CITY OF PORTLAND NOTICE OF VIOLATION

April 5, 2005

RE: 88 Pennell Avenue
CBL: 344-D021

An evaluation of the property at 88 Pennell Avenue on March 24, 2005 revealed that the work completed under permit #03-0939 and 03-117 performed by you fails to comply with the 1999 BOCA Building Code of the City of Portland Code of Ordinances. The following is a list of the violations:

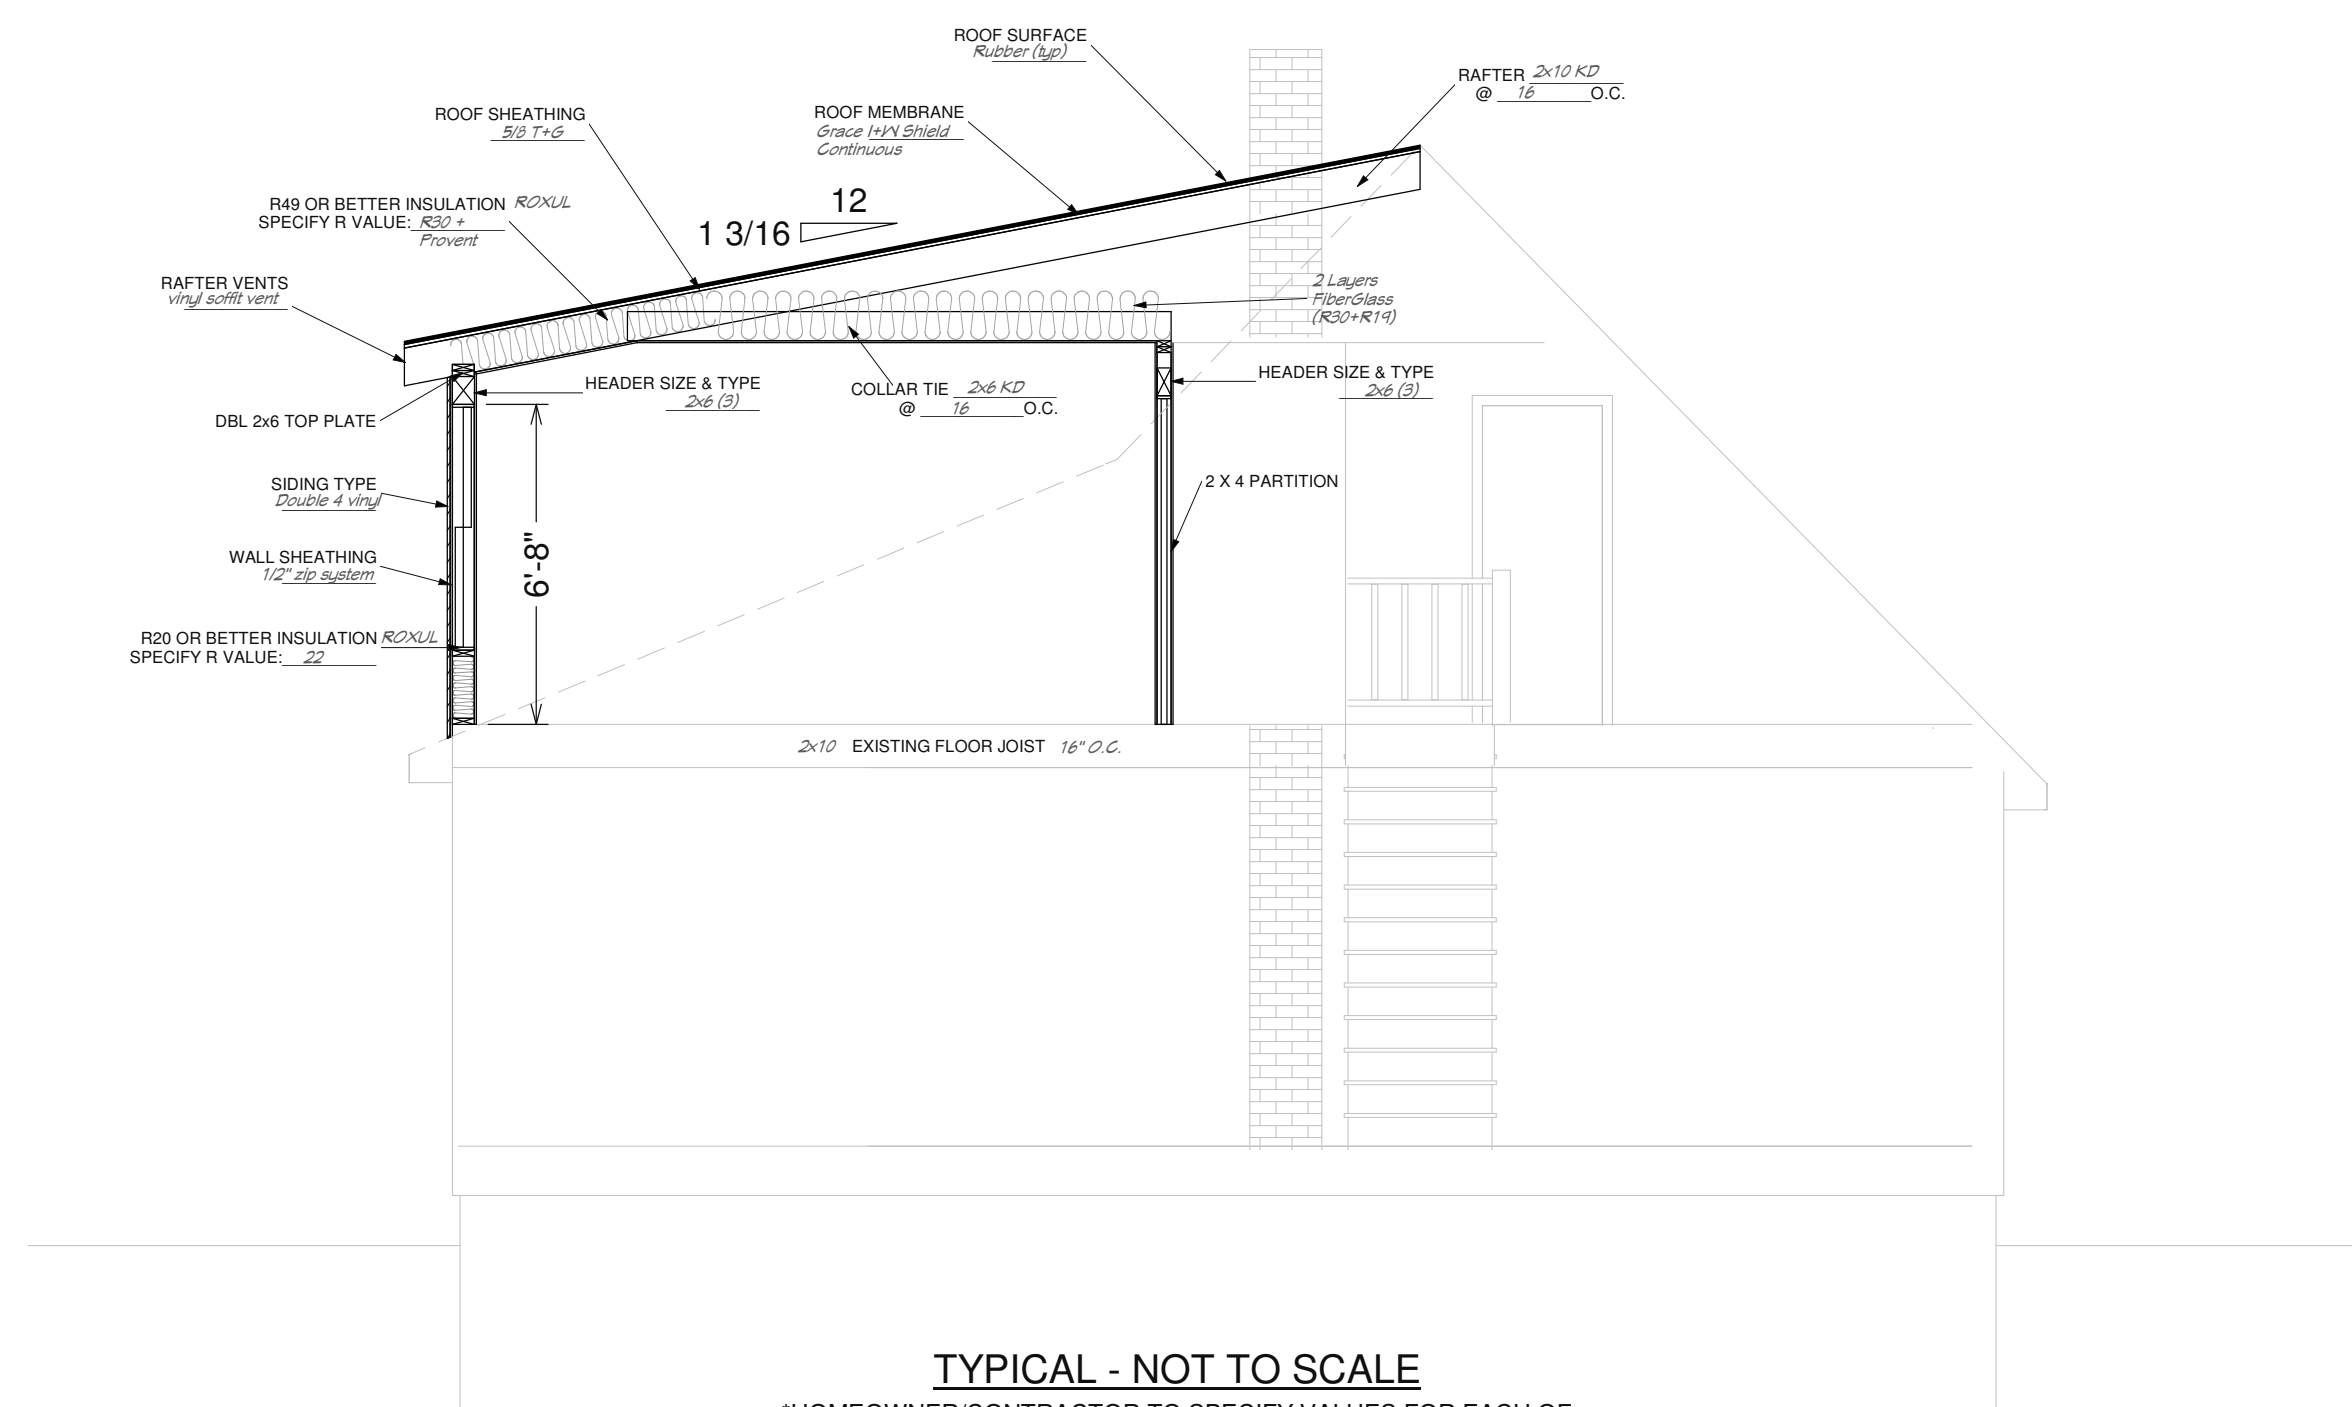
2305.6.2 Support and anchorage on walls or beams: First floor joists in basement are not properly supported on hangers or a ledger strip.

The inspection performed of the roof rafters and second floor joists was inconclusive. Please provide evidence of how these systems are properly supported by the **LVL**.
